Application by Mallard Pass Solar Farm Limited for an Order Granting Development Consent for Mallard Pass Solar Project- EN010127

Submission by John Hughes: ID ref: 20036141

APP-057 Fields 18,19 & 26

Drawing file: published-documents / EN010127-000129-Appendix 06.4 Residential Visual Amenity Assessment.pdf

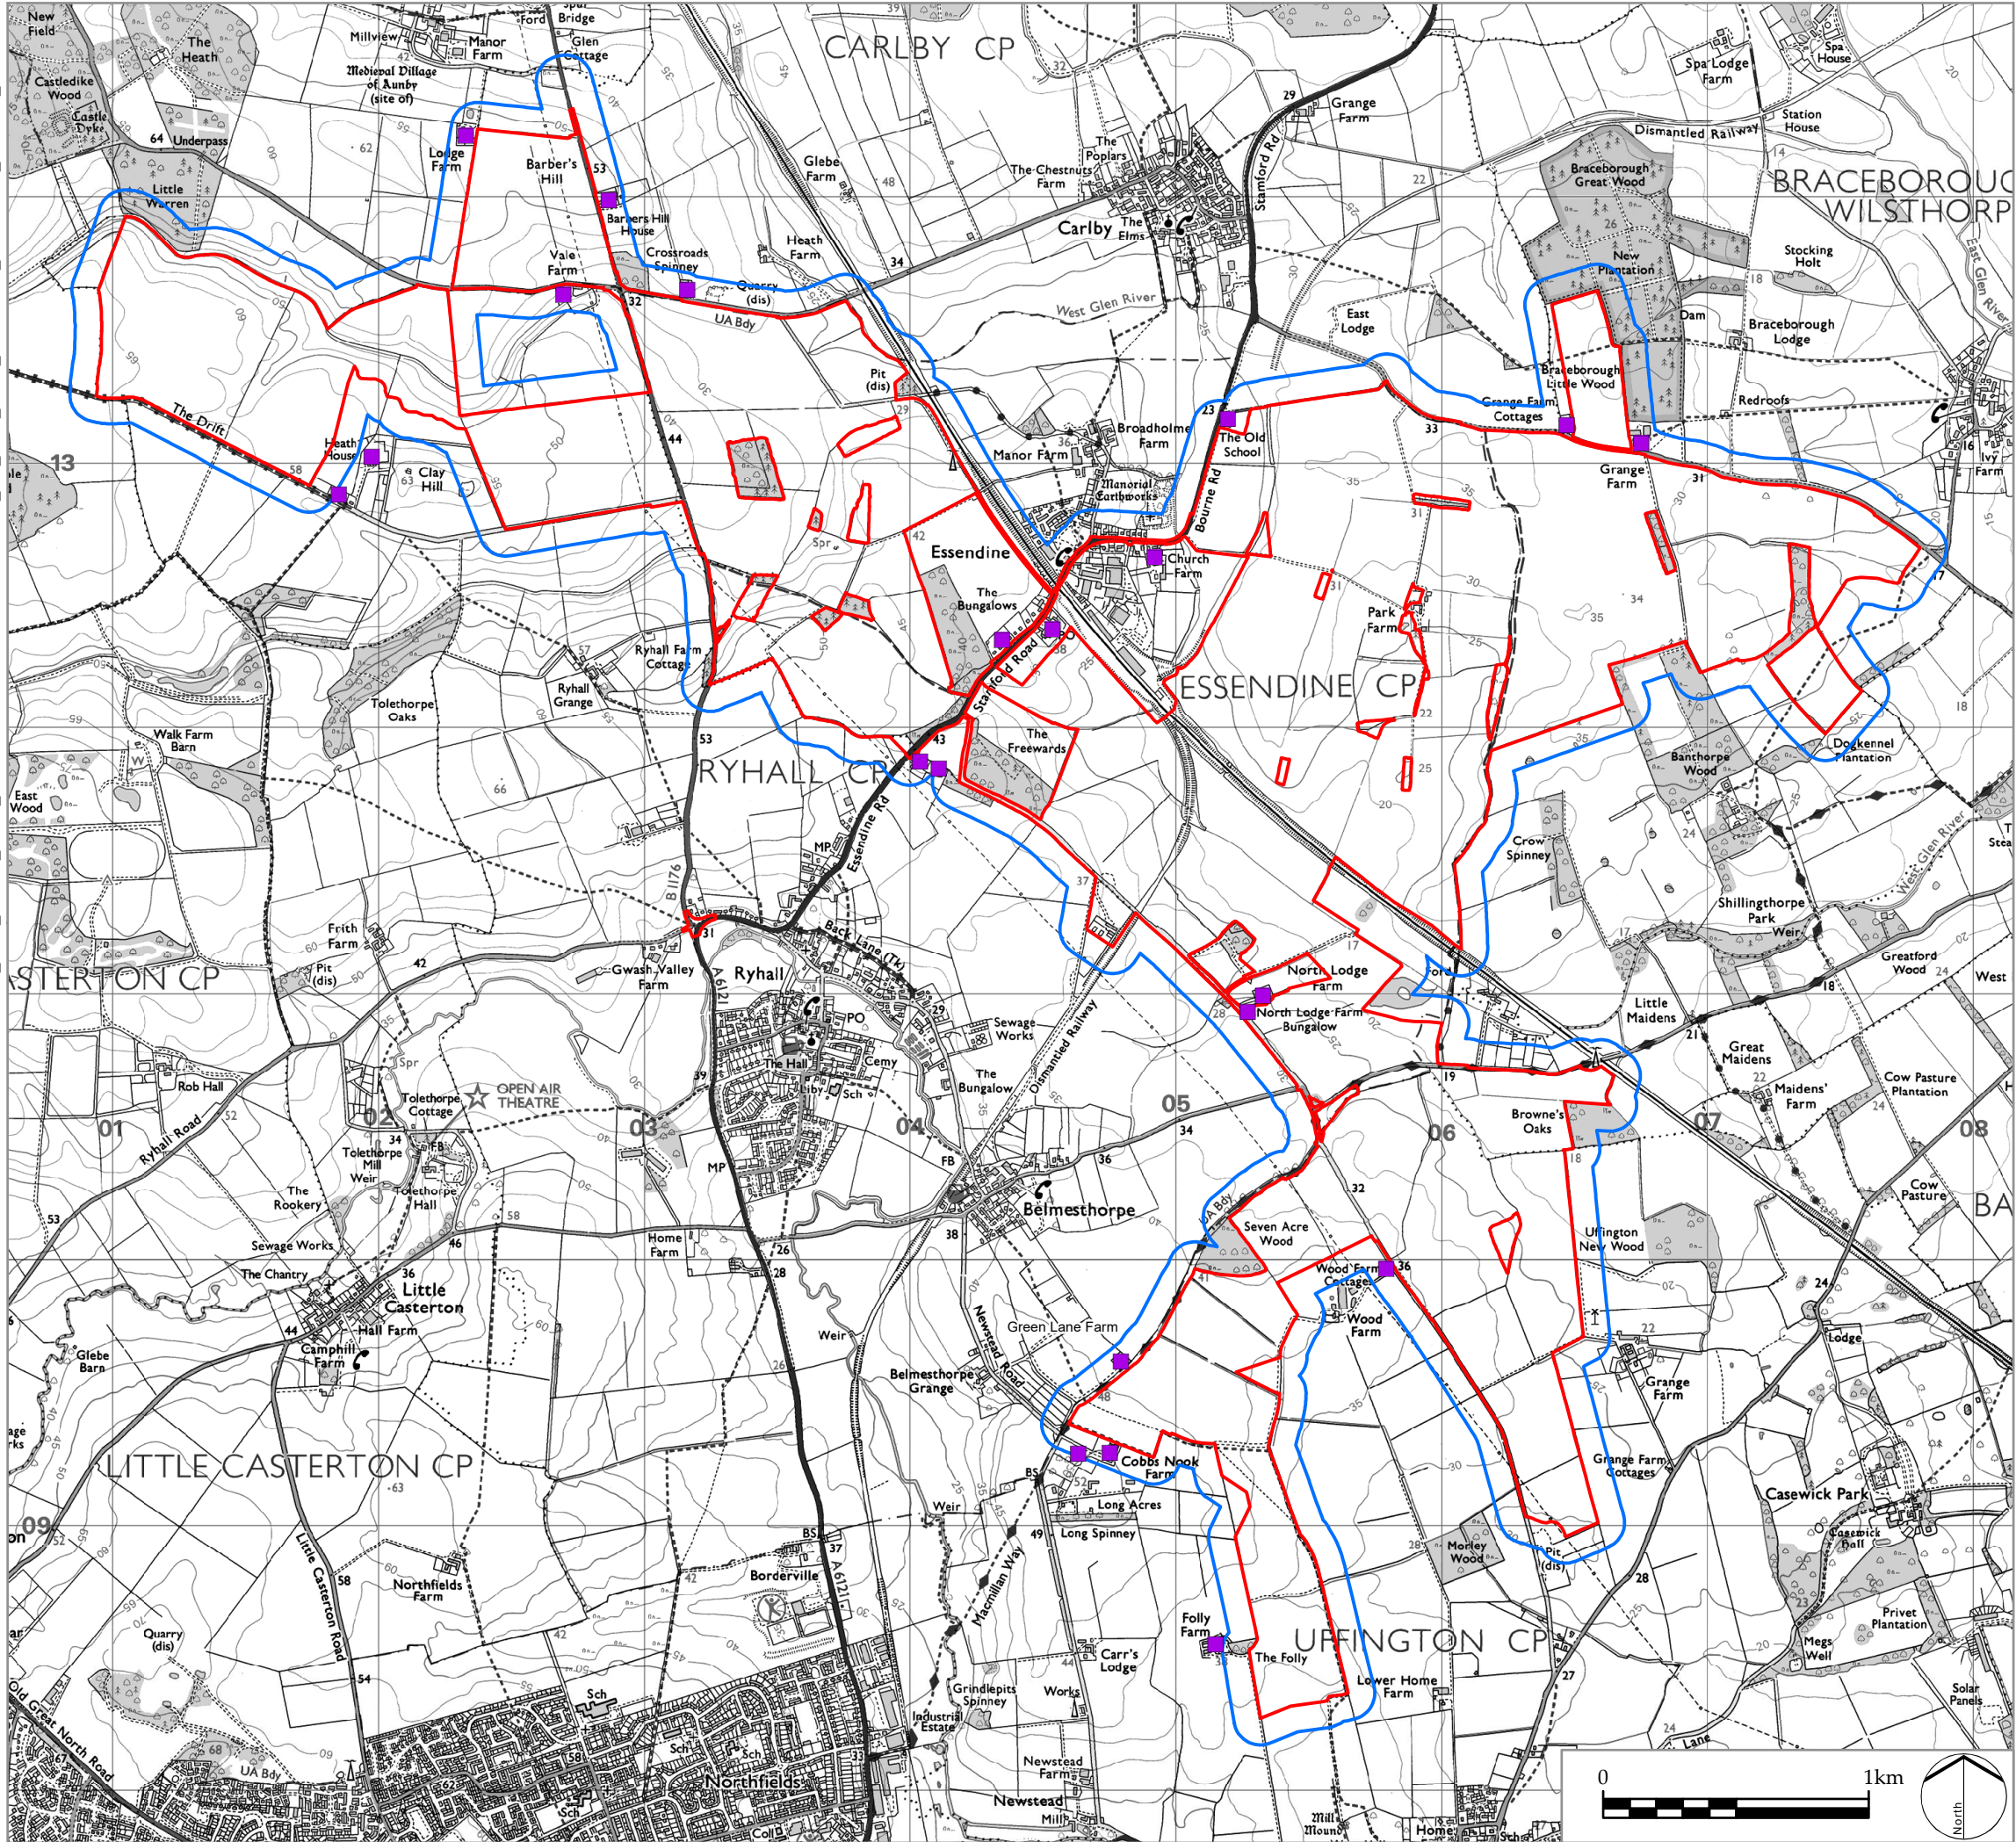
The proposed mitigation measures in EN010127/APP/6.2 submitted by the applicant are wrong as field 26 has never had PV arrays since stage 1 and was always to be retained as arable land. This is a false statement in relation to 'The Bungalows' & 'Glen Crescent' and what mitigating measures the applicant has taken with regards to residents west of the ECML.

I asked questions in REP1-034 to which I still don't have answers, but reading MPSF APP-057 you would think they had addressed them. I asked if PV arrays could be removed from field 18 which has not occurred and there never were any in field 26 as it was the location for BESS which were removed.

Q. Why in the 'Residential Visual Amenity Assessment' Table 1 in relation to [redacted] and [redacted] is the Magnitude of Change 'Low/Negligible and the Significance of Effect 'Slight' considering based on current plans both the new substation field 19 and PV arrays in field 18 will highly visible

a) Field 26 falls away from [redacted] and [redacted] from 40m down to 23m (Google Earth)

b) Field 18 rises up from 23m to 39m with its boundary between field 26 & 19 making any PV arrays sited in this field highly visible, mitigated planting would have little effect due to the elevation of 16m is between boundary of Field 26 and 18 and does not take into account the elevation rise in the field.

c). Field 19 the current hardcore location is 36m above sea level, the proposed substation at 13m high would take the elevation to 49m and no mitigated planting is considered between field 18 and 19
